East Anglia TWO Offshore Windfarm

Appendix 10.1

Fish and Shellfish Ecology Consultation Responses

Applicant: East Anglia TWO Limited
Document Reference: 6.3.10.1
SPR Reference: EA2-DWF-ENV-REP-IBR-000902_001 Rev 01
Pursuant to APFP Regulation: 5(2)(a)

Drawing file: published-documents / EN010078-001116-6.2.10.14 EA2 ES Figure 10.14 Herring Spawning and Nursery Grounds.pdf

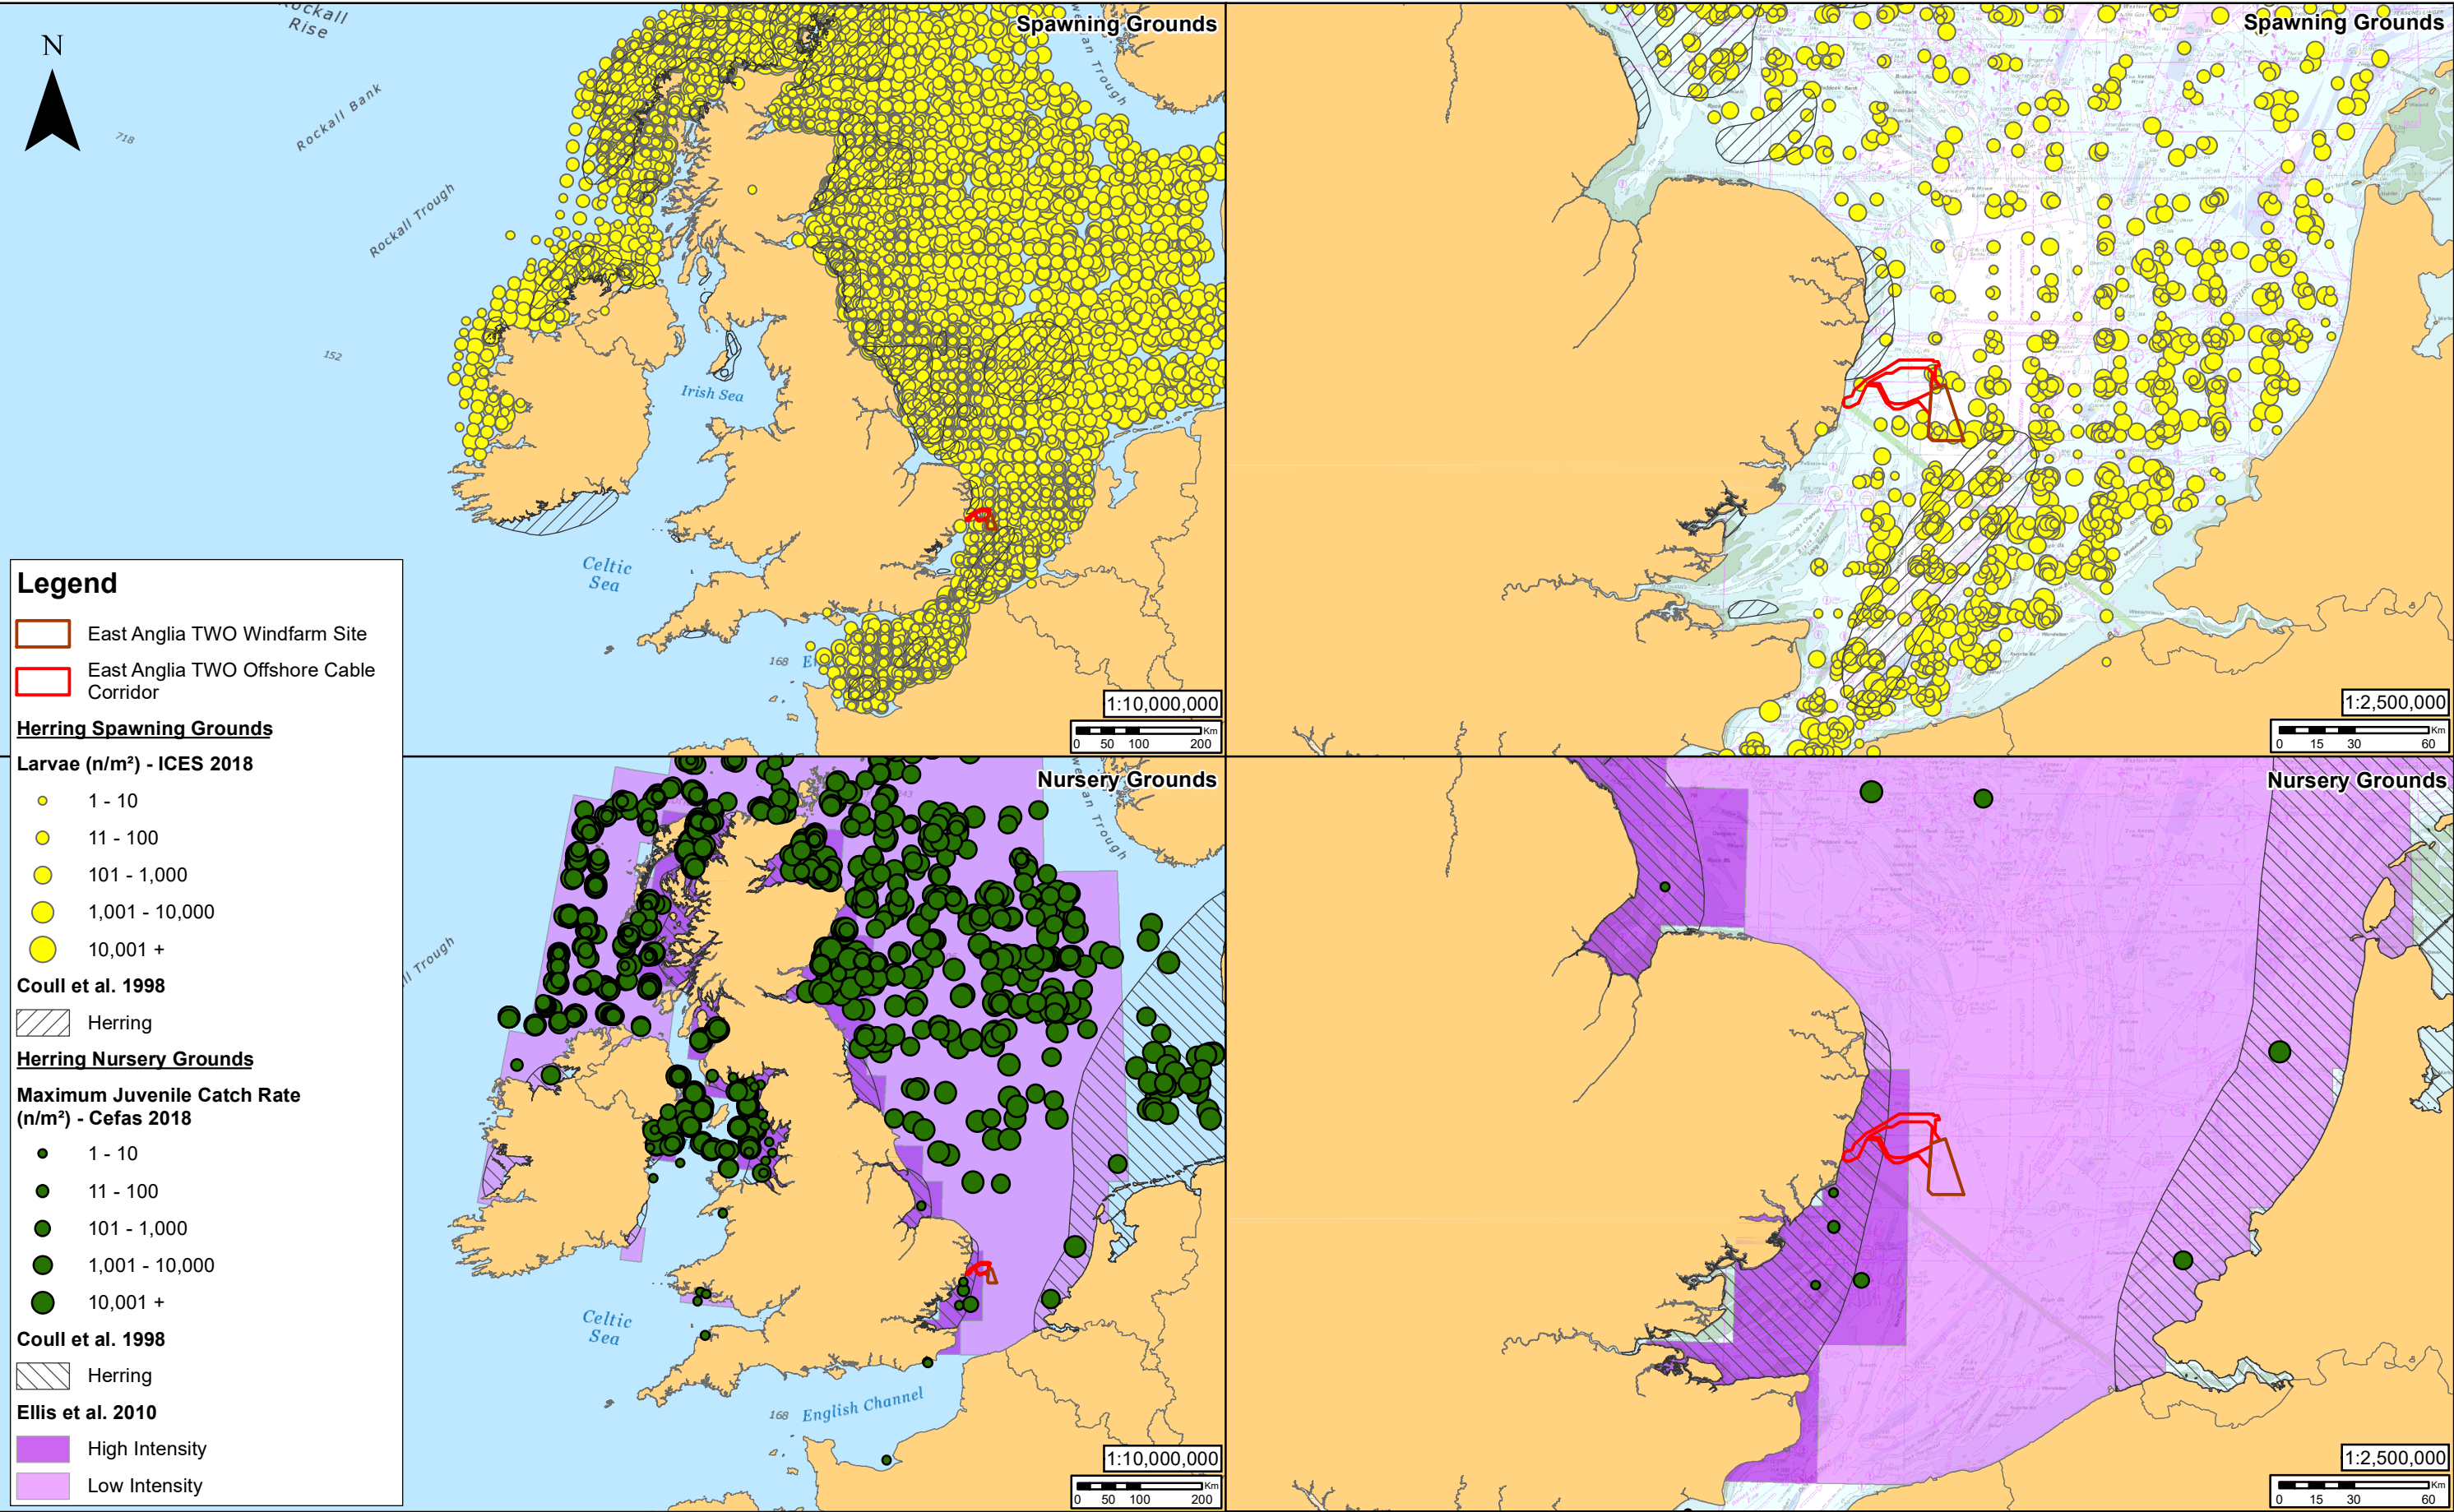
MMO	22/03/2019 Section 42 Response	<p>Further to the above comments (ID 32), If the fleeing was assumed correctly, the predicted Temporary Threshold Shift (TTS) impact ranges for fish are 27km for monopoles and 29km for pin piles, this is a concern as the herring spawning grounds are located only 4.4km to the south towards the English Channel (Chapter 10 paragraph 346) and Chapter 10 paragraph 205 acknowledges that the impact ranges associated with</p>	<p>Noted, additional noise modelling has been undertaken taking a stationary animal approach. This is presented in Appendix 11.4 and summarised in section 10.6.1.4 in the chapter.</p>

Consultee	Date/ Document	Comment	Response / where addressed in the ES
MMO	22/03/2019 Section 42 Response	The MMO does not agree with the conclusion that “based on the known spawning grounds of herring, there is low potential for the underwater noise associated with the construction of East Anglia TWO to impact on the herring during spawning, and therefore there is little potential for cumulative impact on herring spawning with other projects’.” (Chapter 10 paragraph 346). Figure 10.39 shows there is a partial overlap of the 186bD (SELcum) TTS contour with the spawning ground (based on pin piles at 2400kJ hammer energy). It is therefore recommended by the MMO that the potential impacts on spawning herring should be further explored, and the assessment should be based on a stationary receptor. It is also worth noting that the spawning ground may be subject to other noise and non-noise pressures, e.g. shipping, so it is not just limited to other ‘projects’ as such.	Additional noise modelling has been undertaken taking a stationary animal approach. This is presented in Appendix 11.4 and summarised in Appendix 10.3 . Noise from other activities during construction is presented in section 10.7.2.2 .

Consultee	Date/ Document	Comment	Response / where addressed in the ES
		the potential TTS onset have the potential to overlap with the herring spawning grounds to the southeast. It is further stated on page 13 of Appendix 11.3 that “basing the assessment on a stationary (zero flee speed) receptor is likely to greatly overestimate the potential risk to fish species, especially when considering the precautionary nature of the parameters already built into the cumulative exposure model’. However, the MMO believes that basing the assessment on a fleeing receptor is likely to underestimate the potential risk to fish species.	
MMO	22/03/2019 Section 42 Response	Due to the uncertainty caused by the use of fleeing model and the proximity to an important spawning ground. The MMO considers that mitigation in the form of a piling restriction during the herring spawning period may be justified.	As discussed in section 10.6.1.4.5.2 in the chapter, whilst the East Anglia TWO windfarm site is 4.4km from the herring spawning ground (Downs Stock) data from the International Herring Larvae Survey (IHLS) shows that the main important area for herring spawning is located further to the south towards the English Channel (Figure 10.45). Furthermore, it is unlikely that maximum hammer energies would reach 100% and therefore the area of overlap of piling impact with the Downs Stock would be considerably smaller than 7.49%, as presented in the chapter.
